Our ref: XA/2025/100270/04-L01

Date: 7 October 2025

ISSUE SPECIFIC HEARING 2 (ISH2) INTO ENVIRONMENTAL MATTERS

BOTLEY WEST SOLAR FARM, OXFORDSHIRE

**Illustrative Masterplan
Figure 5.5F: Cable Corridor Option F**

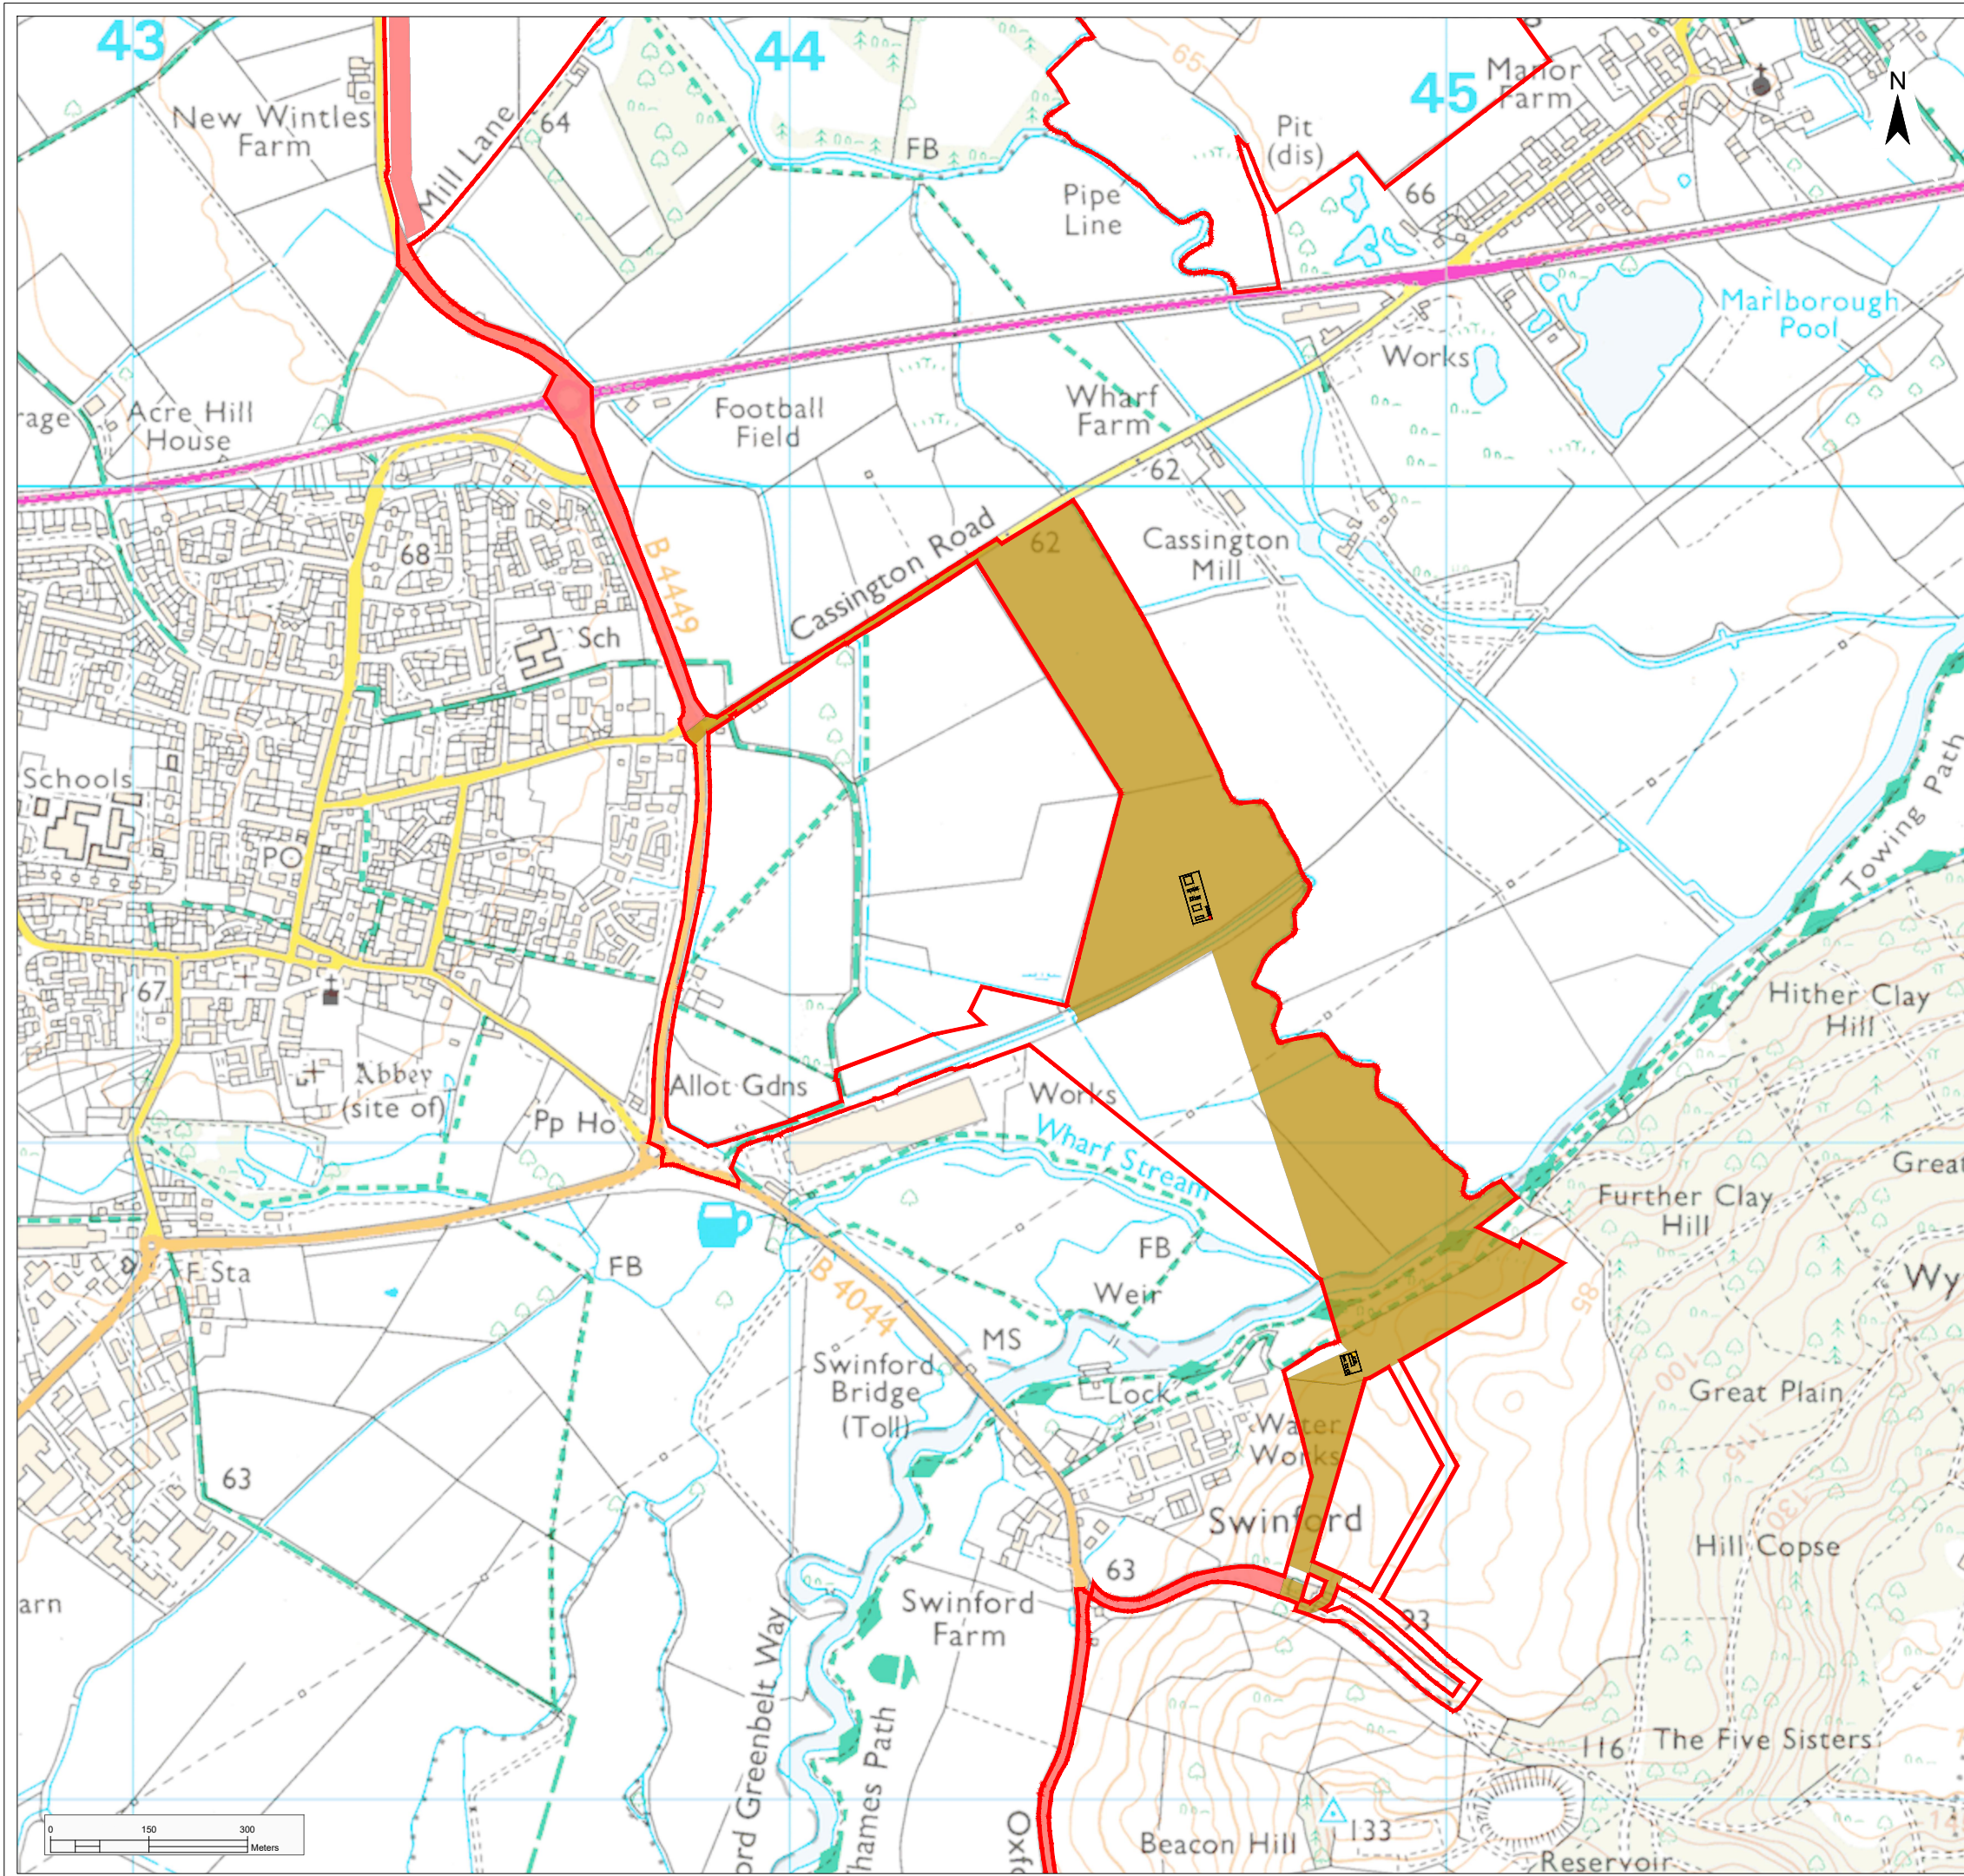
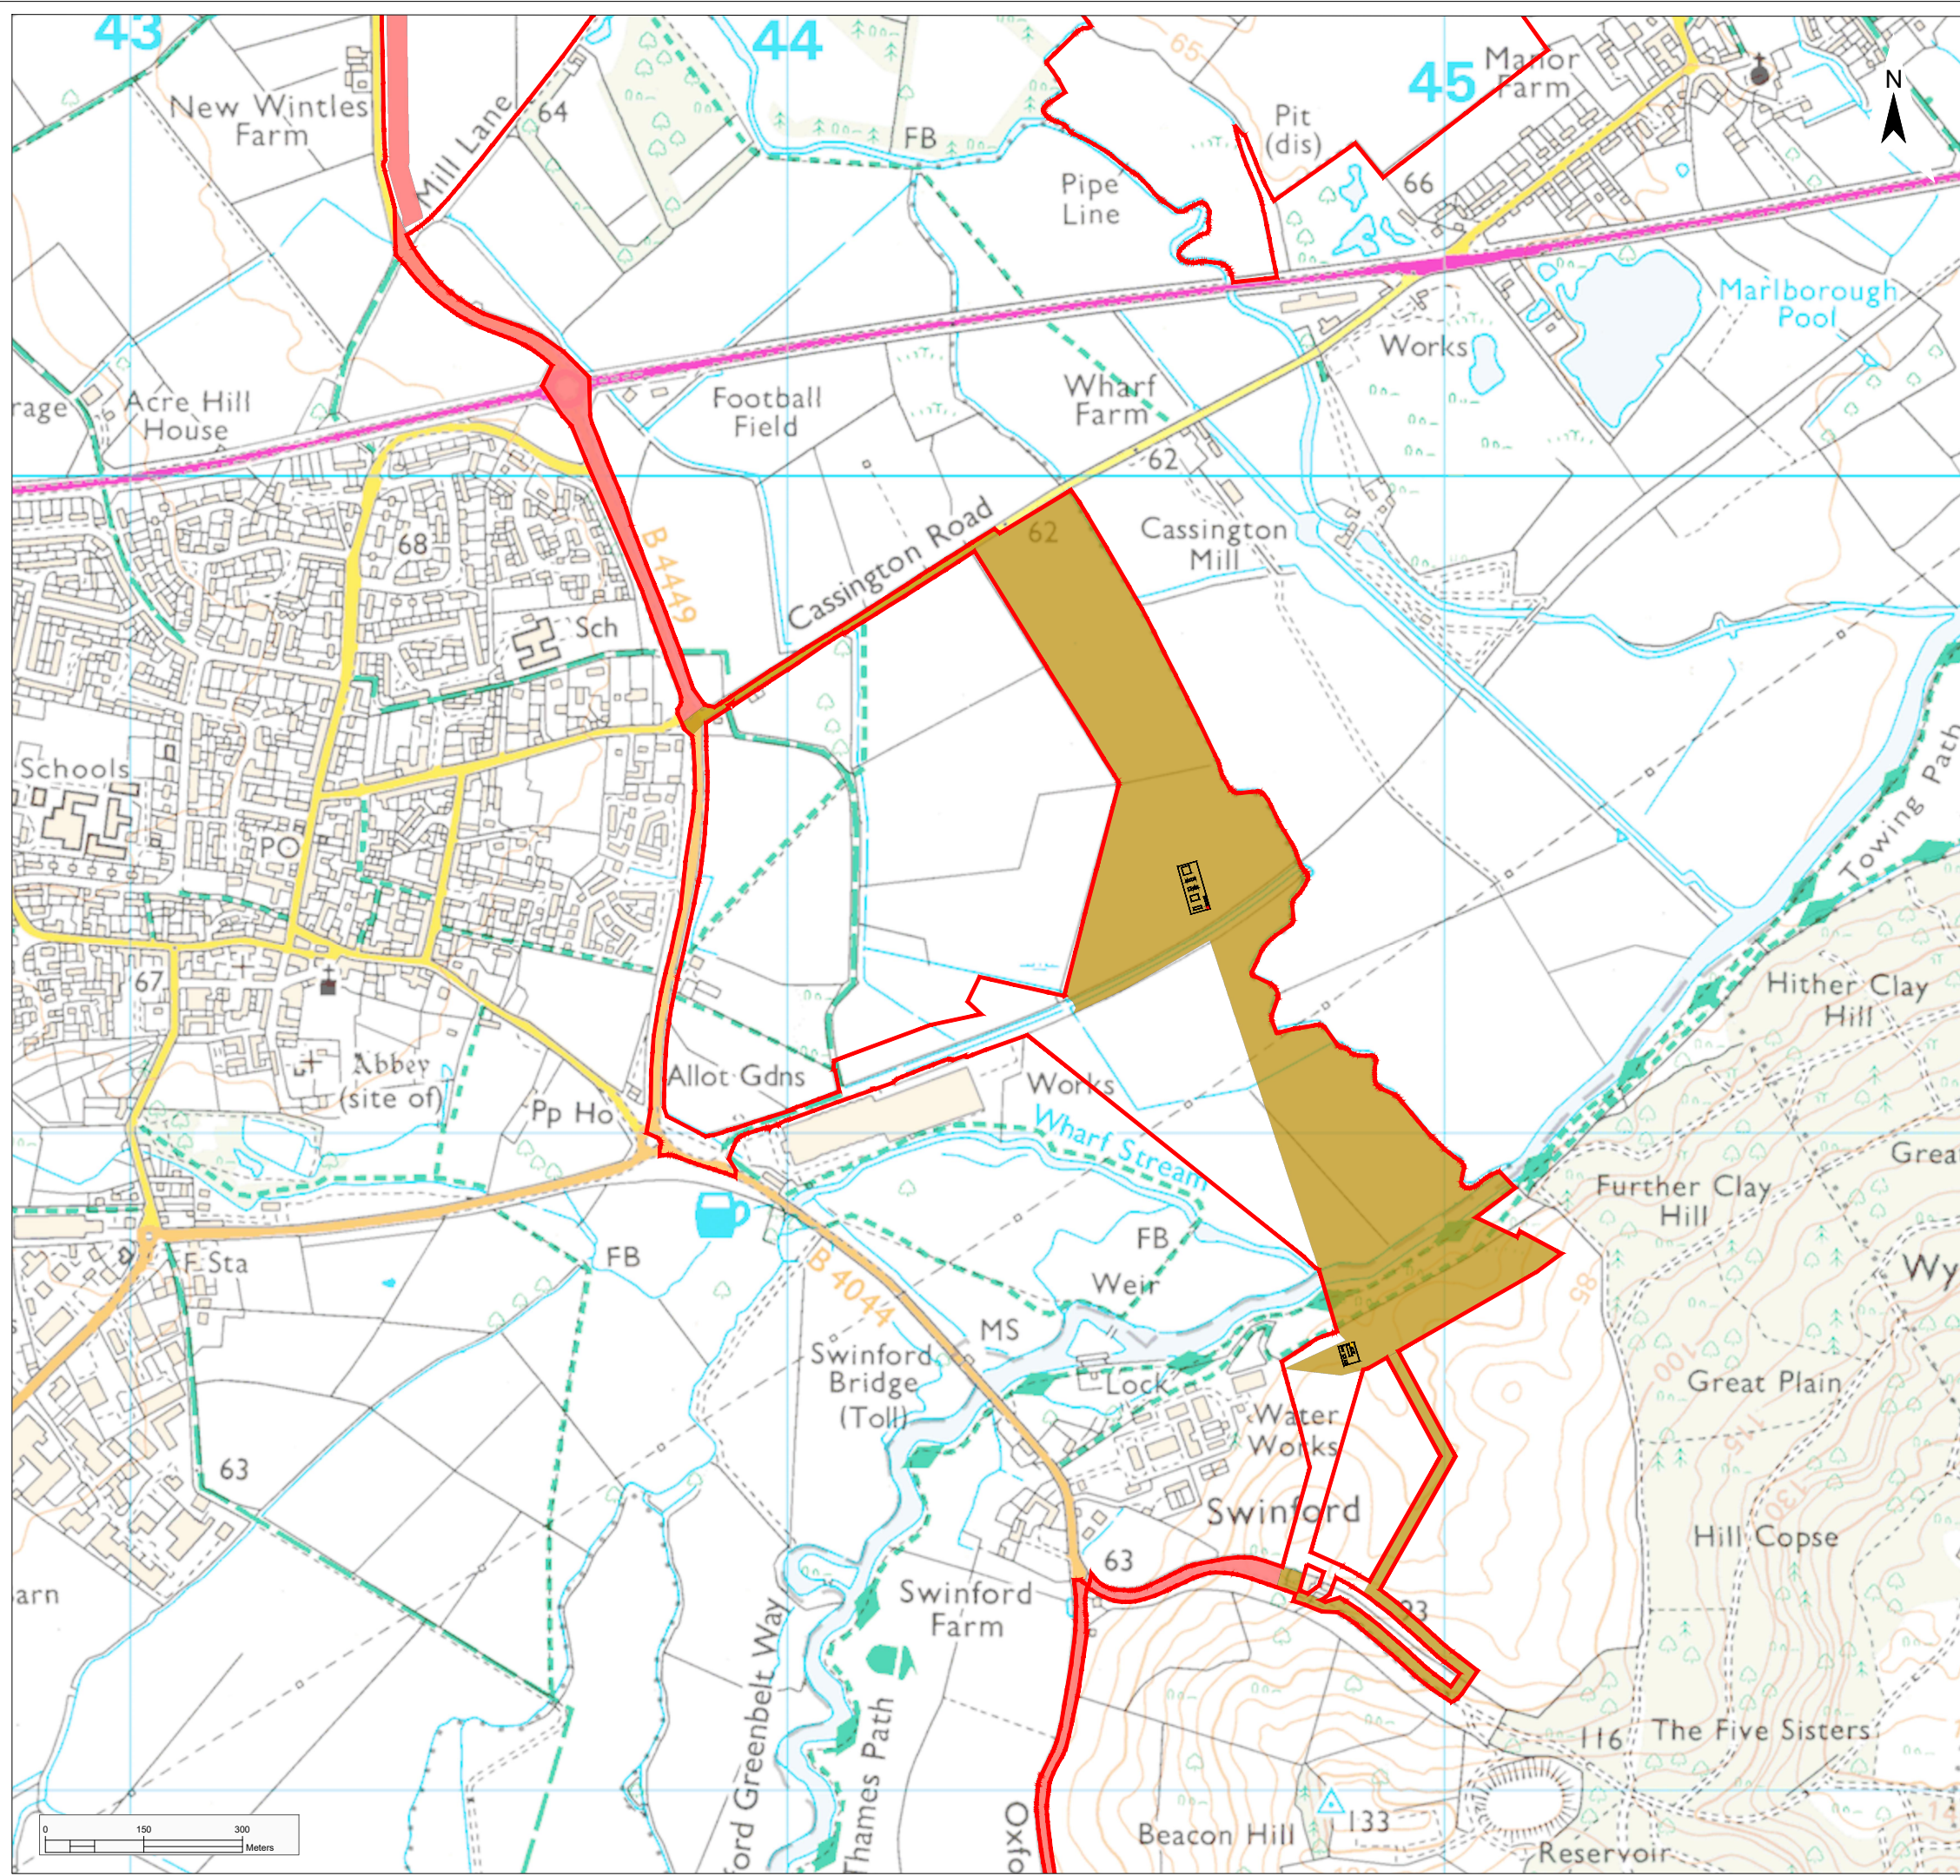
Flood Zones 3a and 3b / ES, FRA	EAFR-009 – Provide mapping that shows Flood Zones 3a and 3b with proposed components and the cable corridor route. Minimise interaction with Flood Zone 3b.					<p>The Swinford HDD entrance pits are shown to be within the extent of Flood Zone 3b within the West Oxfordshire Strategic Flood Risk Assessment. The latest Risk of Flood from Rivers and Sea (RoFRS) dataset shows the chance of flooding from rivers and the sea considering the presence and condition of flood defences. The Swinford HDD entrance pits are at a high-risk classification based on this dataset. A high-risk classification has a greater than or equal to 1 in 30 (3.3%) chance of flooding in any year. I would suggest using the Risk of Flooding from Rivers and Sea dataset for informing the risk to the entrance pits rather than solely the outlines from the River Thames as the RoFRS dataset will incorporate the risk from other watercourses as well such as the lower River Evenlode. In addition to the modelled outlines, the Swinford HDD crossing entrance pits are also shown to be within the Winter 2013/14 recorded flood extent, January 2003 recorded flood extent, and the Winter 2000 recorded flood extent. Given the location of the entrance pits within a high-risk flood area, there is also potential for flood flow routes through the HDD tunnel to the opposite bank of the Thames. The applicant should assess this risk and clearly outline the mitigation measures.</p> <p>The applicant will need to review this with respect to the Swinford HDD entrance pit and provide written justification as to why the entrance pit cannot be moved outside of functional floodplain. In such cases,</p>

<p>appropriate mitigation measures must be presented to manage and reduce flood risk. It is important to note that mitigation measures may remain relevant even if the HDD entrance and exit pits are located within Flood Zone 3a, as this is still an area at risk of flooding.</p>
--	--	--	--	--	--	--	--	---
